RE: Pamela Road Extension/Subdivision Amendments

Northeast Civil Solutions (NCS) is in receipt of comments from Woodard and Curran.

Comments Provided by David Senus, P.E.

INFILTRATION SYSTEM #1
SCALE: 1" = 10'

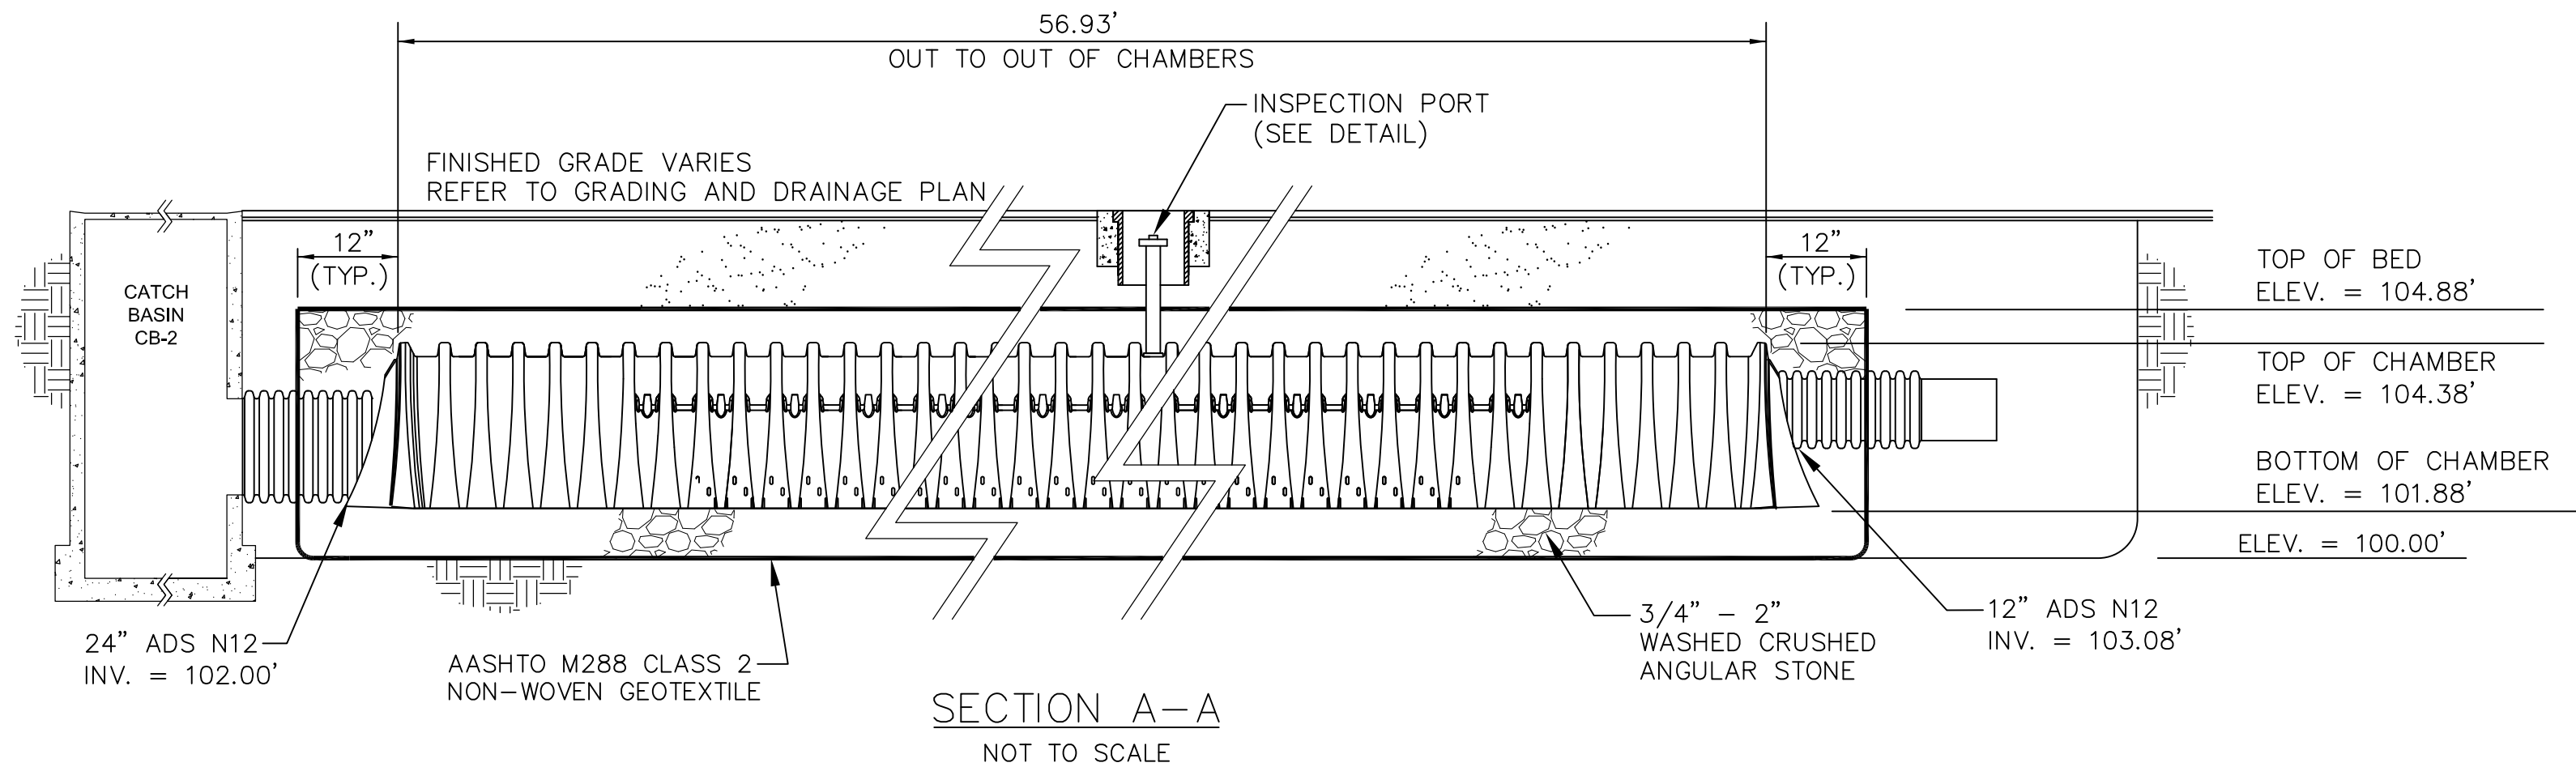
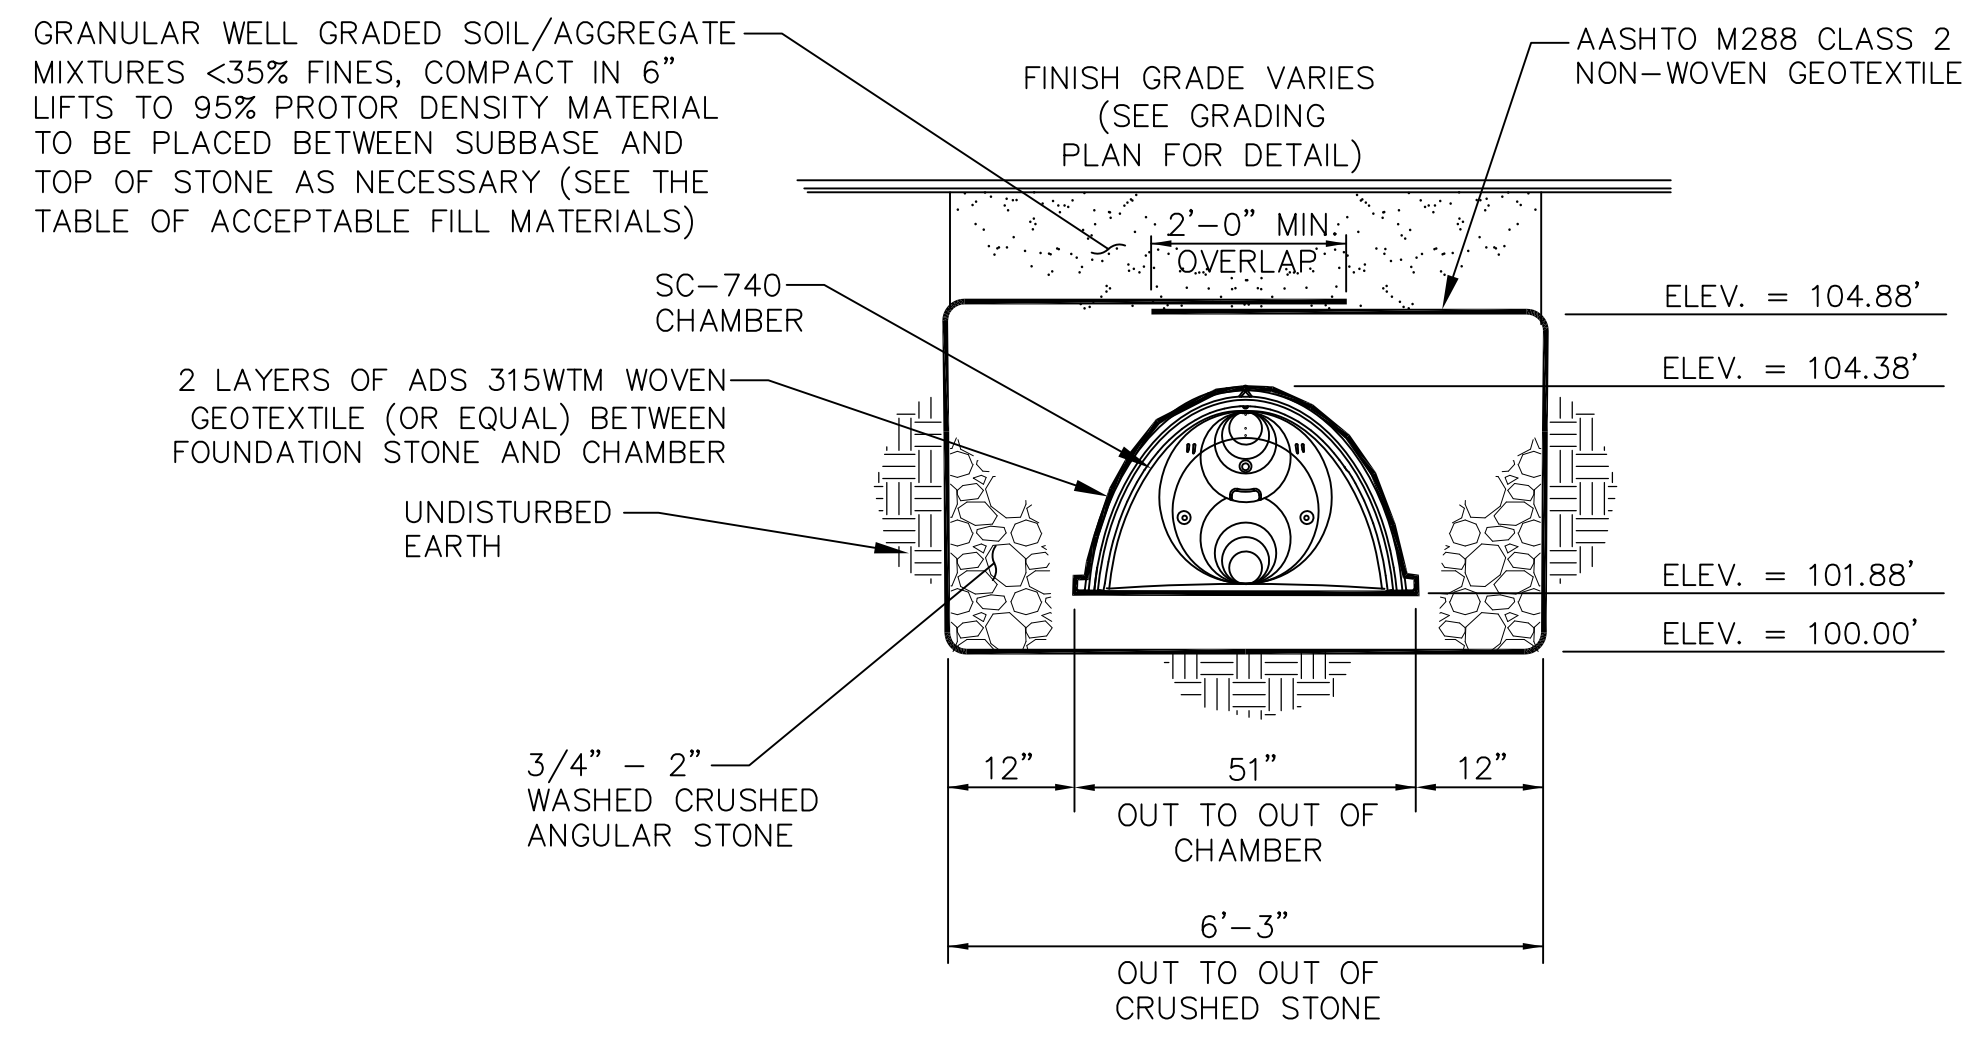
3) Two layers of woven geotextile fabric shall be placed between the stone and the Isolator Row chamber (at the interface between the stone and the chamber). As proposed on Sheet 12, the Applicant has shown 2 layers of geotextile between the stone and the surrounding backfill but no geotextile between the chamber and the stone (note: only one layer is required between the stone and the surrounding backfill). **The detail has been revised to call for two layers of geotextile between the Isolator Row chamber and the adjacent stone.**
